## **Application by Longfield Solar Energy Farm Limited for an Order Granting Development Consent for the Longfield Solar Farm project.**

### **The Examining Authority's Written Questions and Requests for Information (ExQ1)**

**Issued on 26 July 2022**

DRAWN: EL **DRAWING NO.:** 4077_LGF_DR_PRE_0008.5

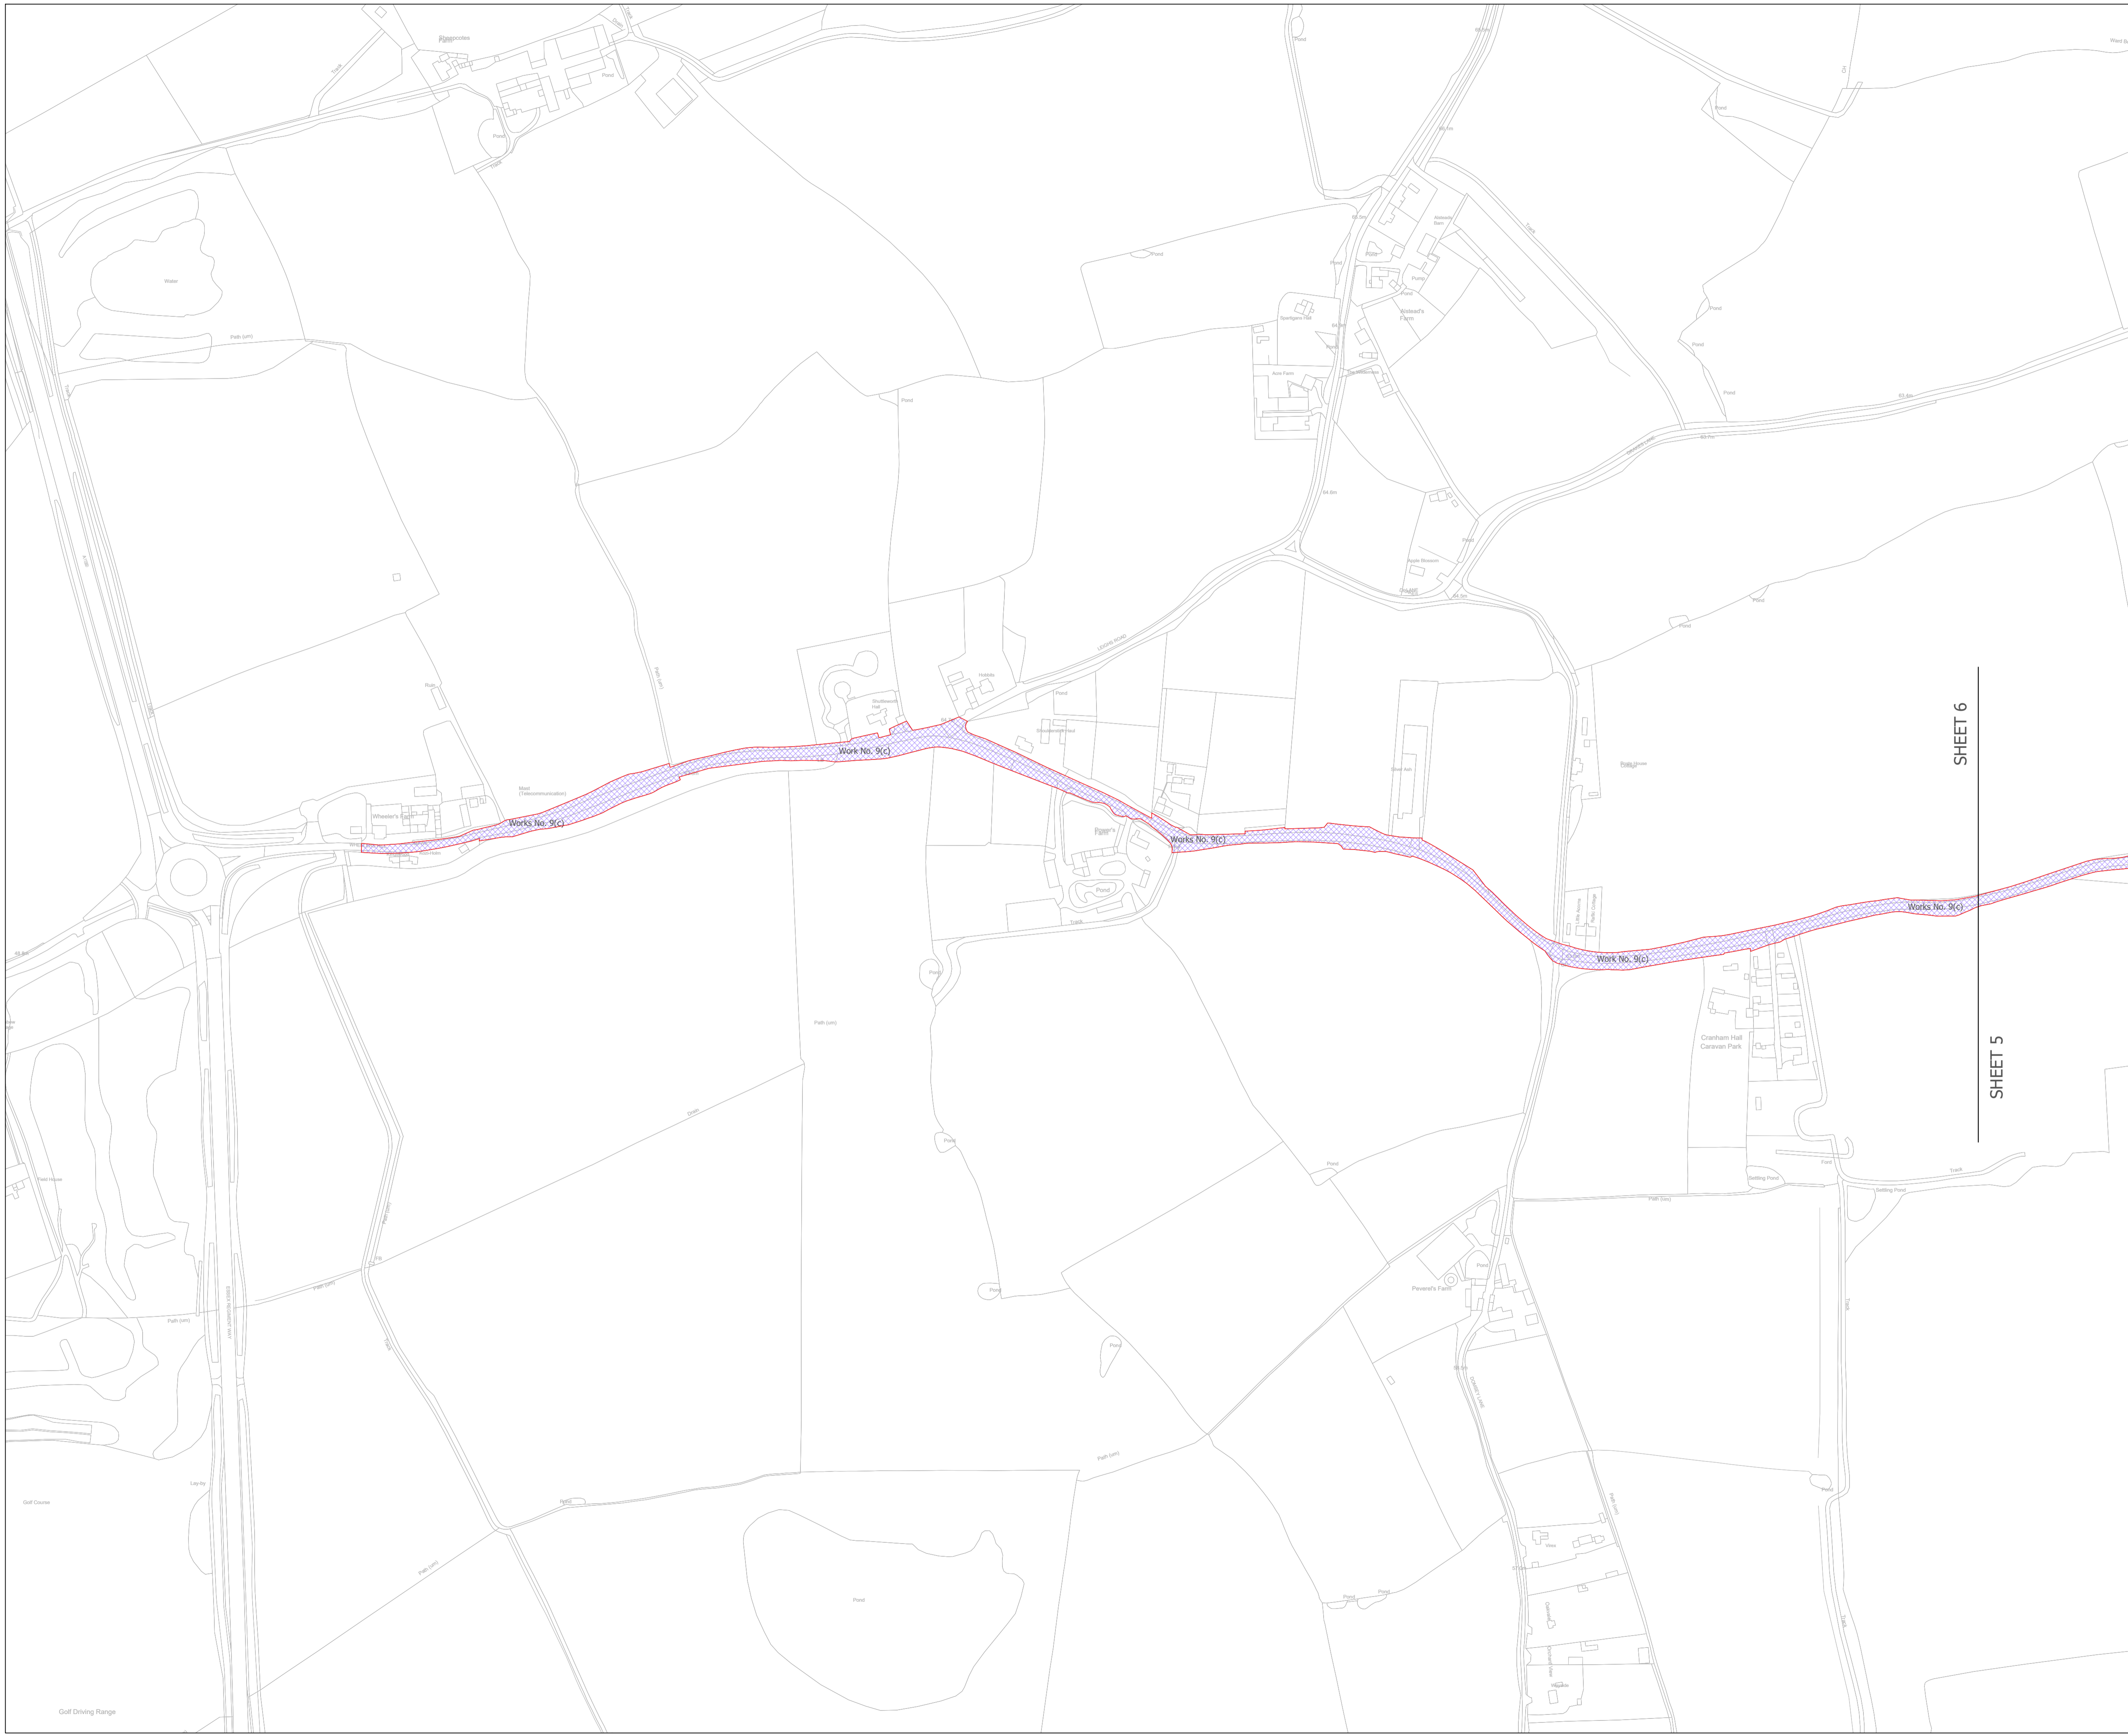
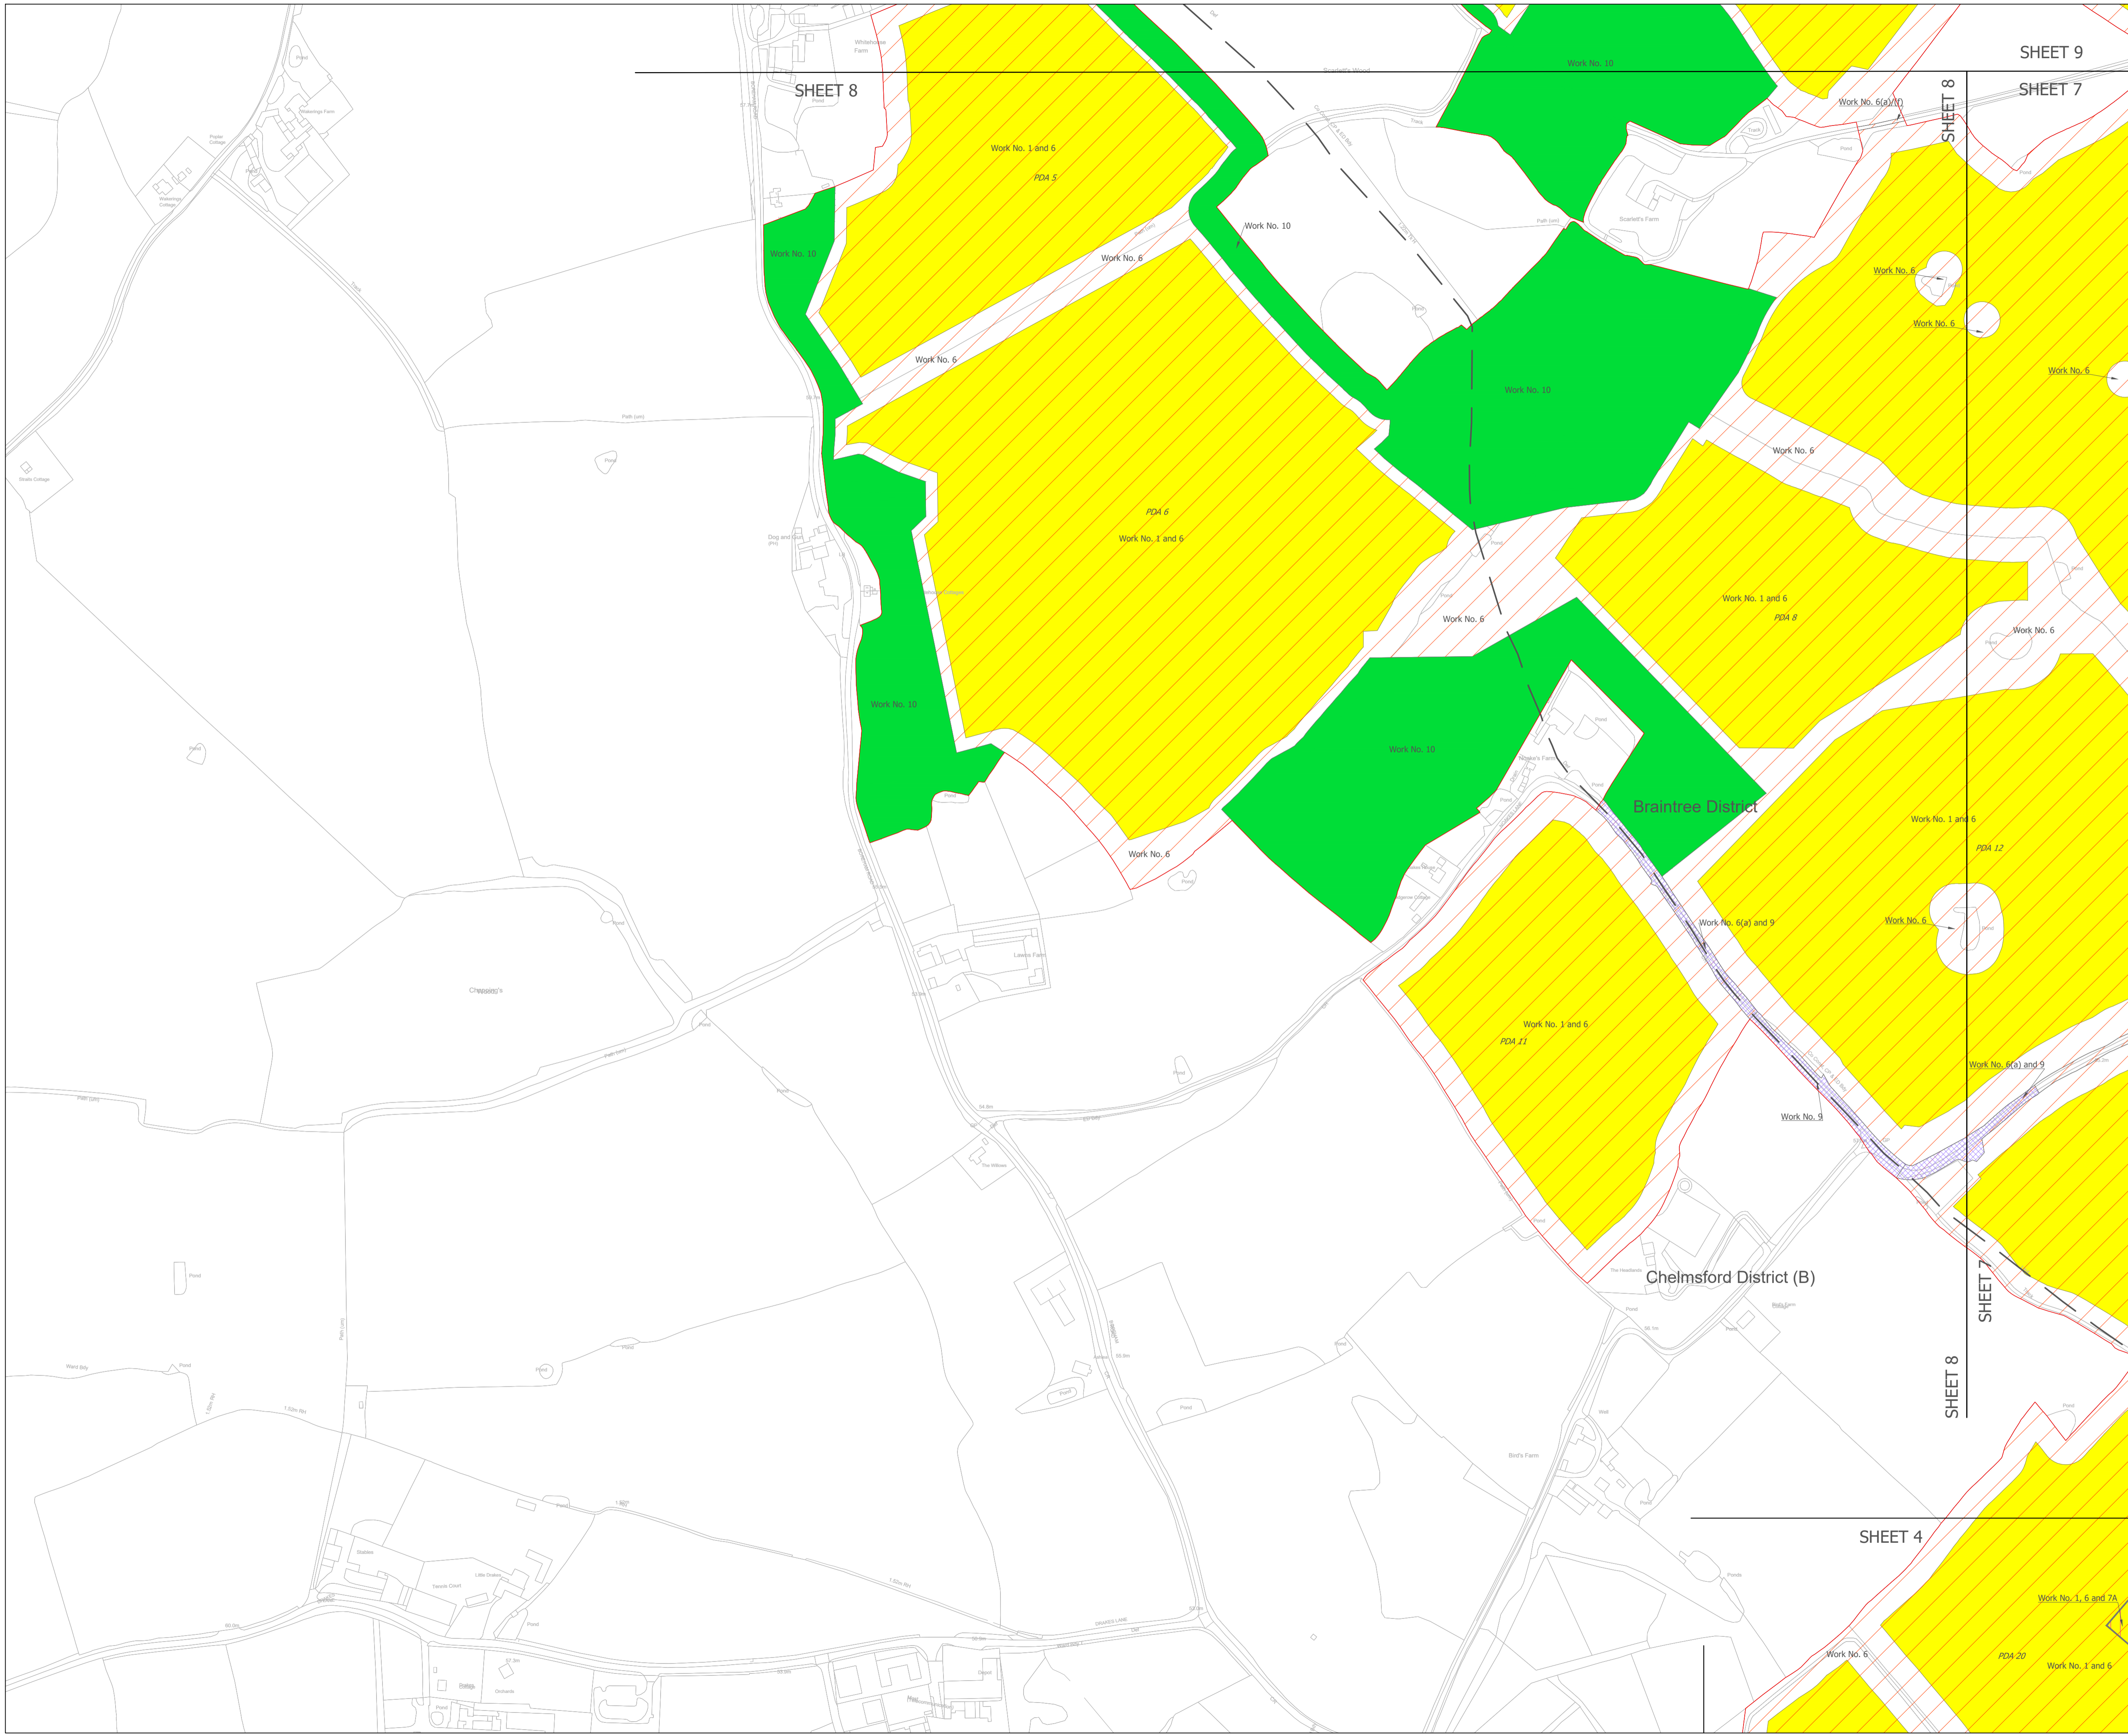
1.3.2	Applicant	The works plans show wide limits of deviation for a number of the works proposed. Please explain why this degree of flexibility is required and confirm that the limits of deviation have been reduced to the minimum extent necessary.
